Date: 7th February 2020

Our Ref: PAA/142/19/

Pre-Application Advice

Reserved matters applications following outline consents Y/88/18 and Y/44/17
Stakers Farm Land north of Yapton C of E School North End Road Yapton BN18 0DU

REV	DESCRIPTION	DATE	AUTHOR	CHECKD
CLIENT				
dandara new homes				
PROJECT				
LAND AT NORTH END ROAD YAPTON				
DRAWING				
BOUNDARY TREATMENT LAYOUT 70 UNIT SCHEME				
SCALE 1:500 @ A1		DATE 02.08.19	AUTHOR LAH	CHECKED -
JOB NO 102-70		DRAWING NO PL-07	REV -	REV -
BRIMSTONE DESIGN LTD

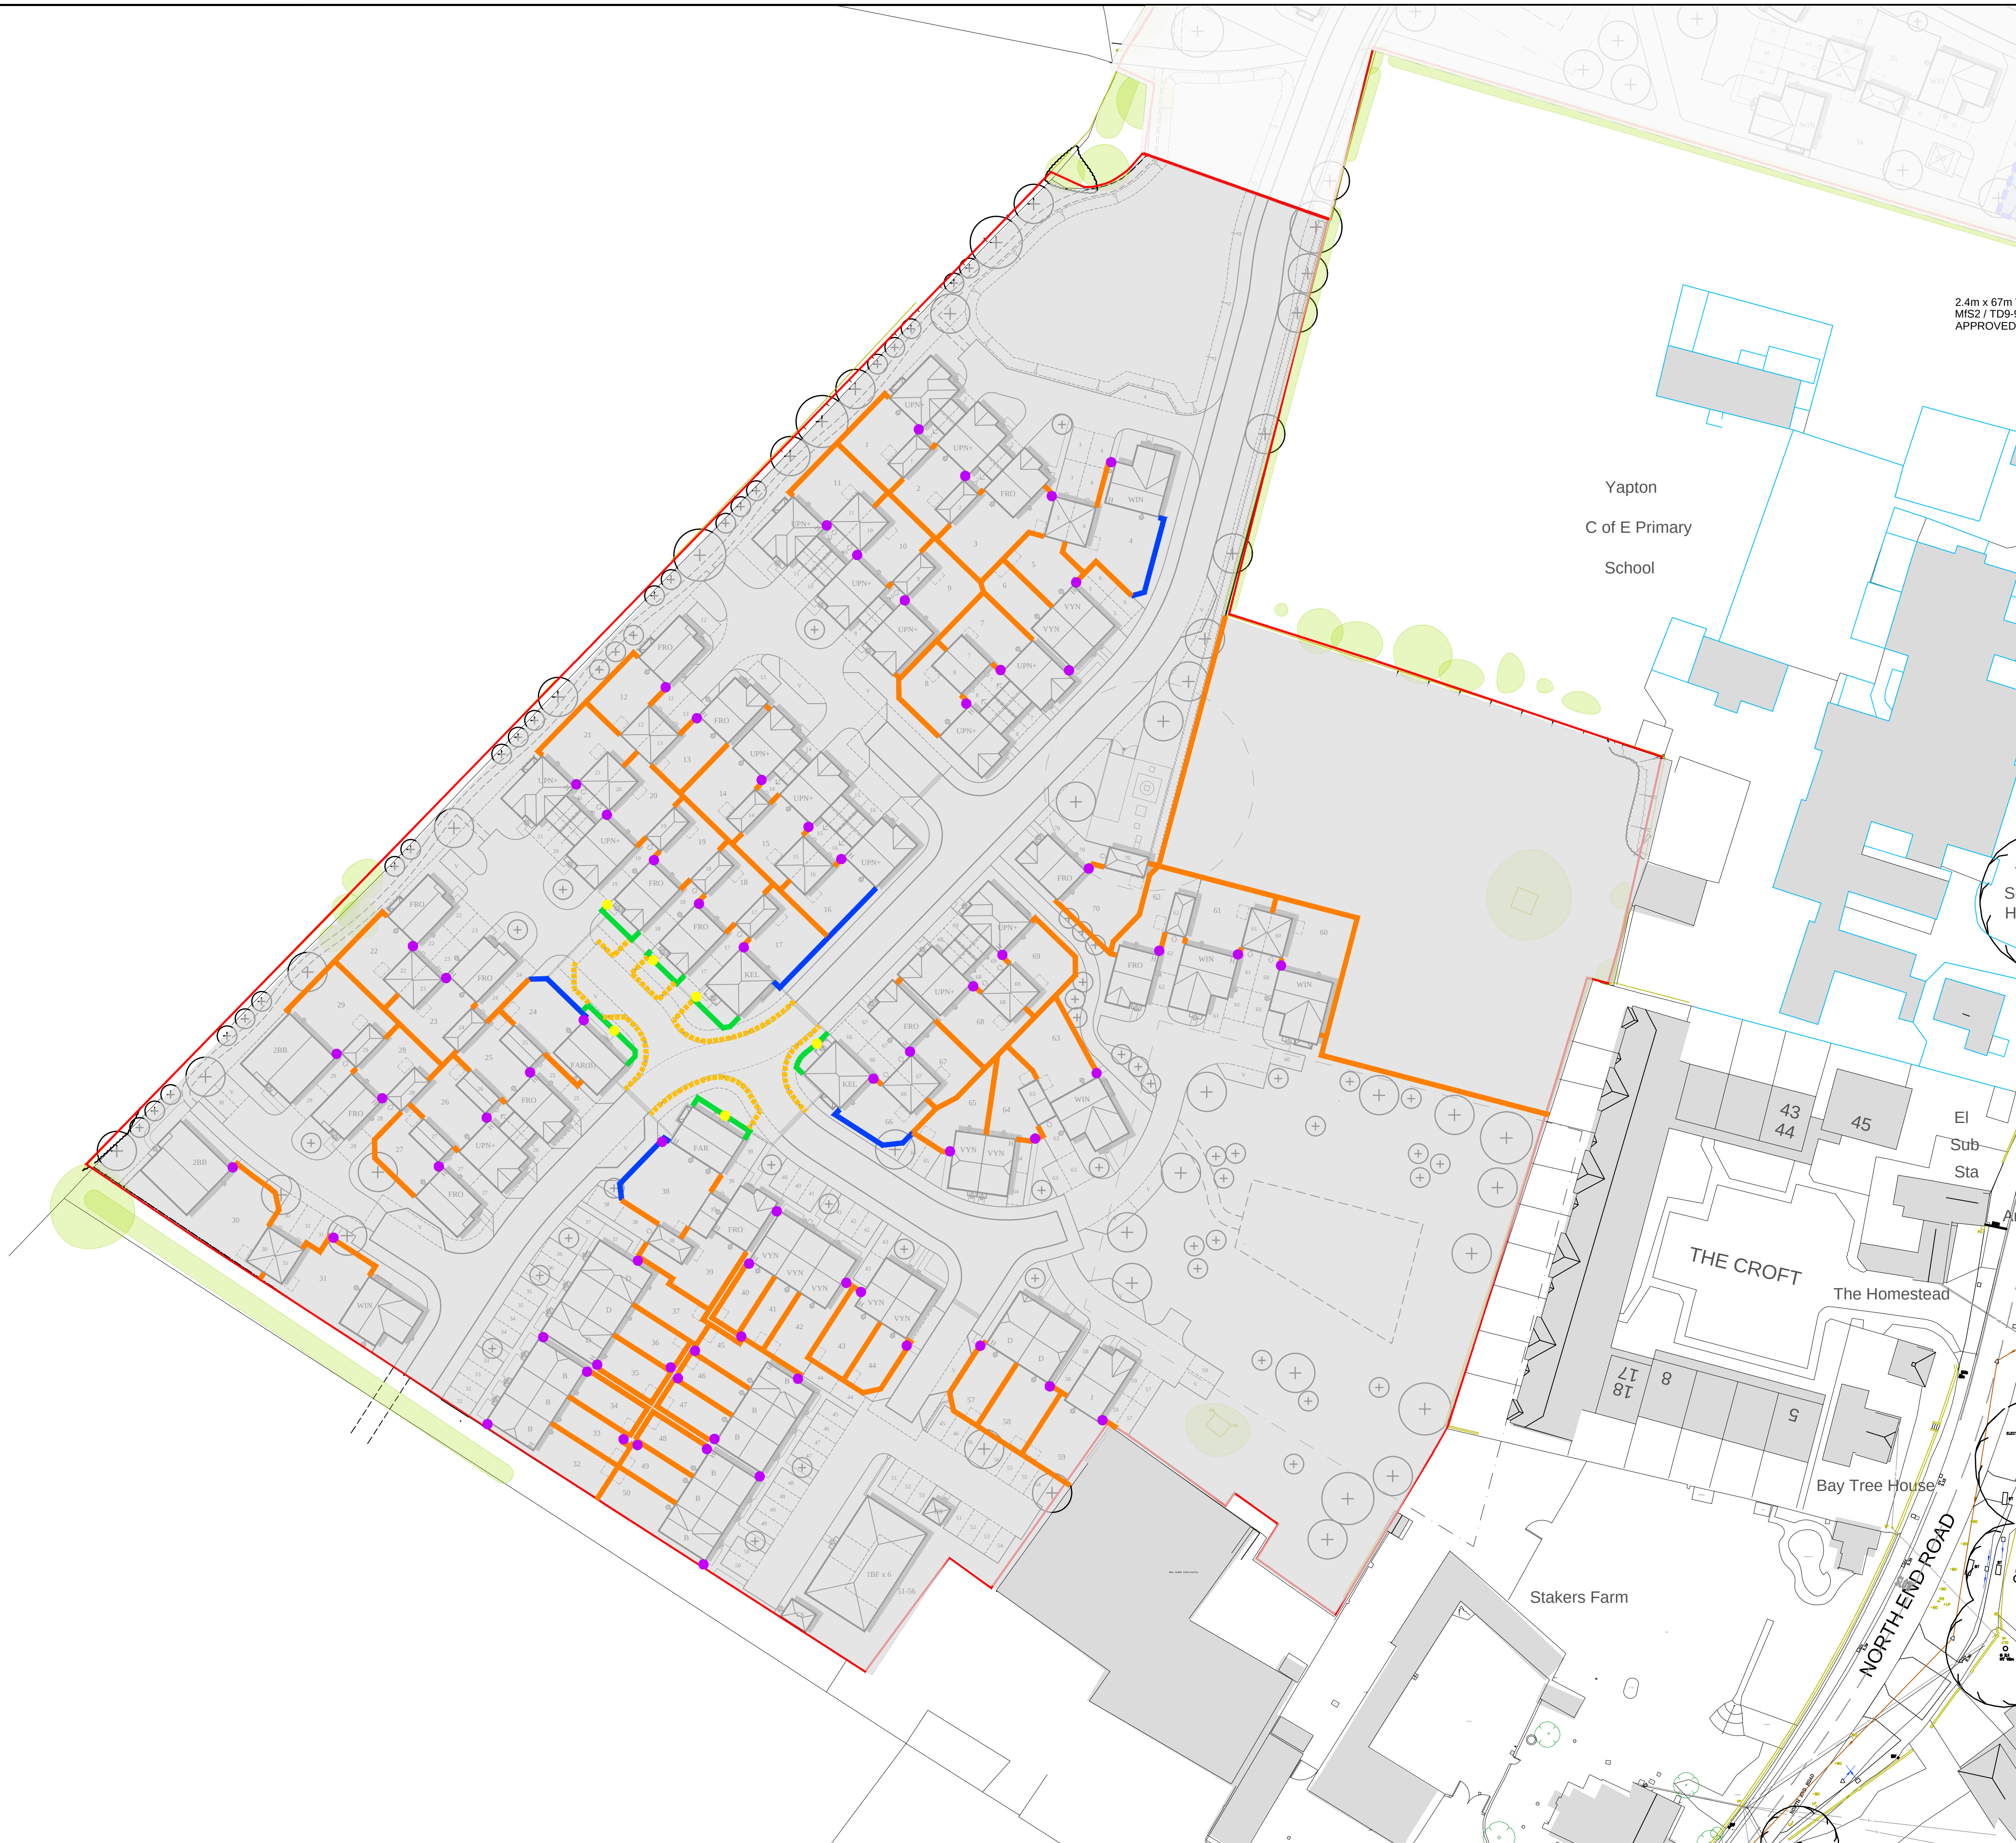
- Overall the layout seems too dense (although we accept that you have permission for 108 dwellings and these must be balanced against our other requirements & the gifted land);
- The parking court area to the rear of plots 72-76 is not an appropriate solution. However, I see on the latest layout that this has been altered in scale & layout. Also, I note that our emerging Design Guide does not rule out the use of parking courts instead stating that: "Rear parking courts should only be provided if all other options are exhausted, and should be small scale and overlooked by housing to ensure safety and crime prevention" (page 77); and
- The North End Road frontage needs a clear frontage. Flint would be appropriate on the boundary walls to this frontage.

- Provision of a pedestrian/cycle path through the scheme from the southern border with the private track to the boundary with Clays Farm;

- Removal of one of the pathways across POS A to create a larger green area;
- Changes to the western buffer planted area to prevent a fenced corridor formation; and
- Provision of a footpath through parts or all of this buffer planting (this would then allow it to be considered as useable POS).

Your proposal is for 7,494m² of POS which would comply with both the previous and current requirements. However, I note that this total includes the buffer planting areas on the western boundary which are shown to have 1569m² worth of space. Our requirement is that all public open space should be useable therefore, we would only allow these buffer areas to be included if there was public access into and through them (i.e. by a footpath).

REV	DESCRIPTION	DATE	AUTHOR	CHECKD
CLIENT				
PROJECT				
LAND AT NORTH END ROAD YAPTON				
DRAWING				
PARKING LAYOUT 70 UNIT SCHEME				
SCALE	DATE	AUTHOR	CHECKED	
1:500 @ A1	02.08.19	LAH	-	
JOB.NO	DRAWING.NO	REV		
102-70	PL-06	-

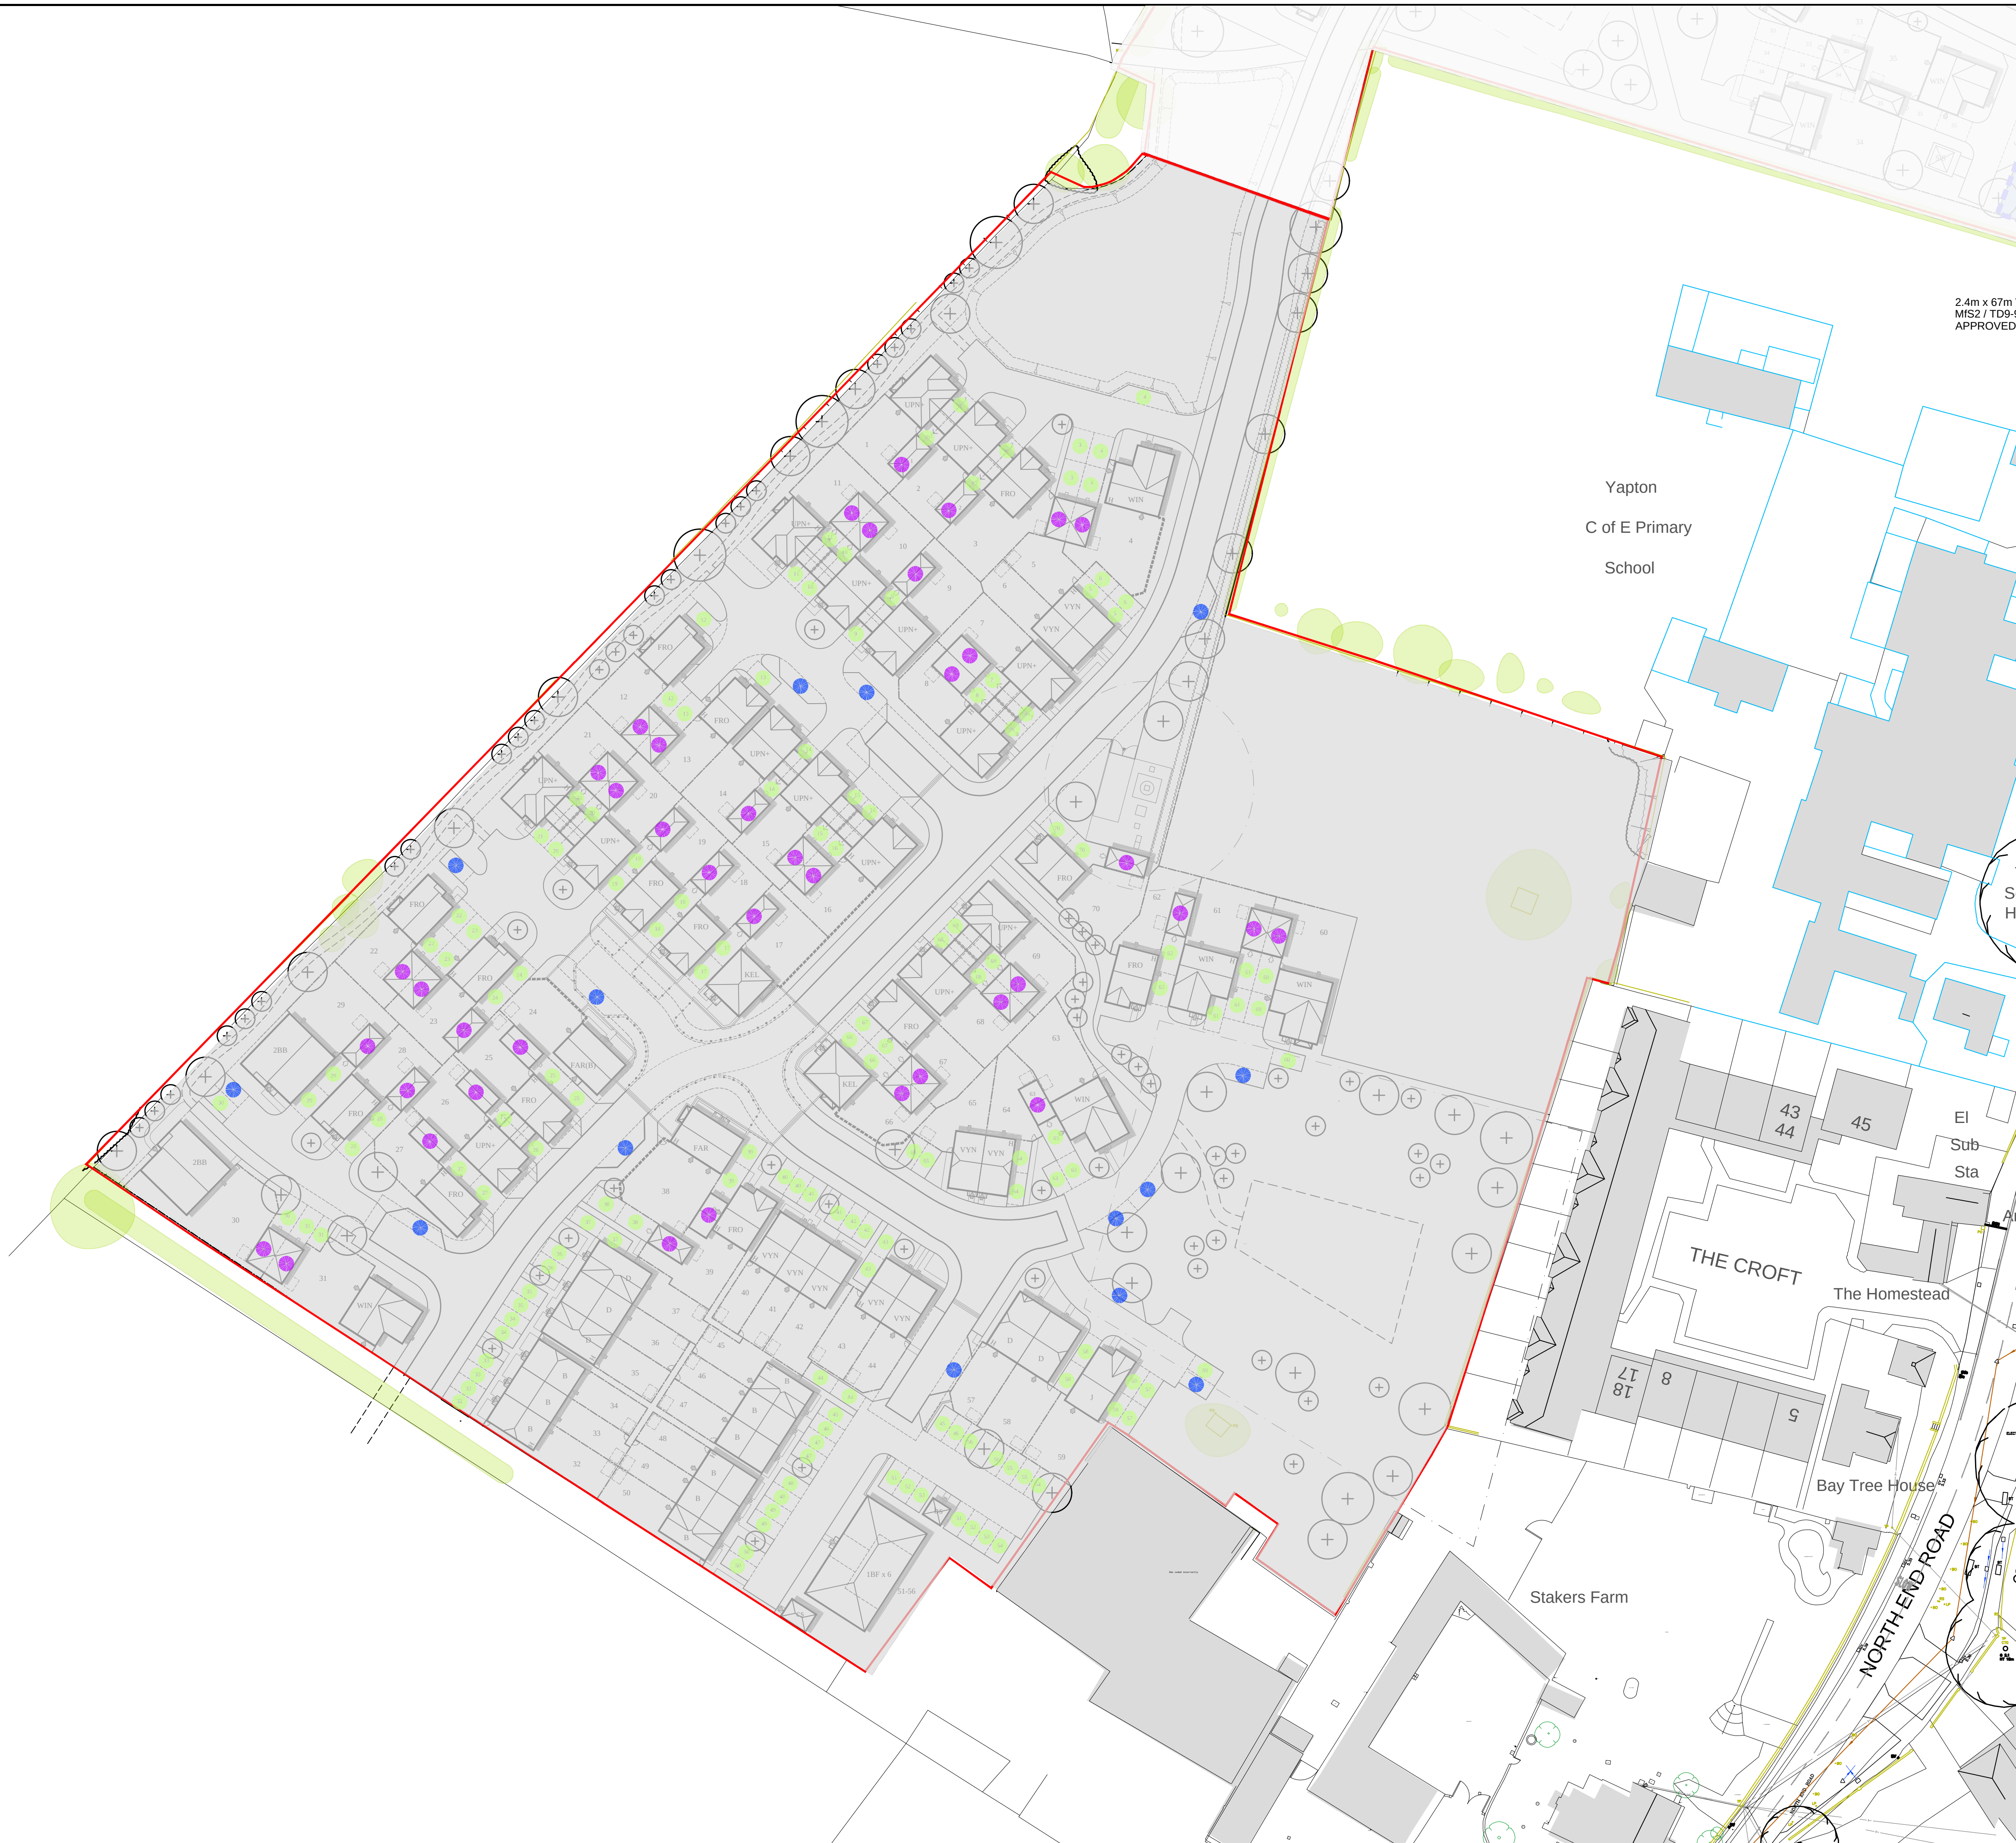
Please also note that all garages, if measuring at least 6m x 3m internally, will only qualify as 0.5 of a space. Car ports/barns however are counted as 1 space. Your proposal does represent a significant shortfall against the new parking standards (and potentially more so if garages are shown as I have not

I am unable to currently say for sure as to whether the proposal will be acceptable or not as this will depend on West Sussex Highways advice in respect of the layout however, the parking shortfall is likely to be a significant concern going forwards and you should note that our Development Control Committee are very keen to see the standards enforced.
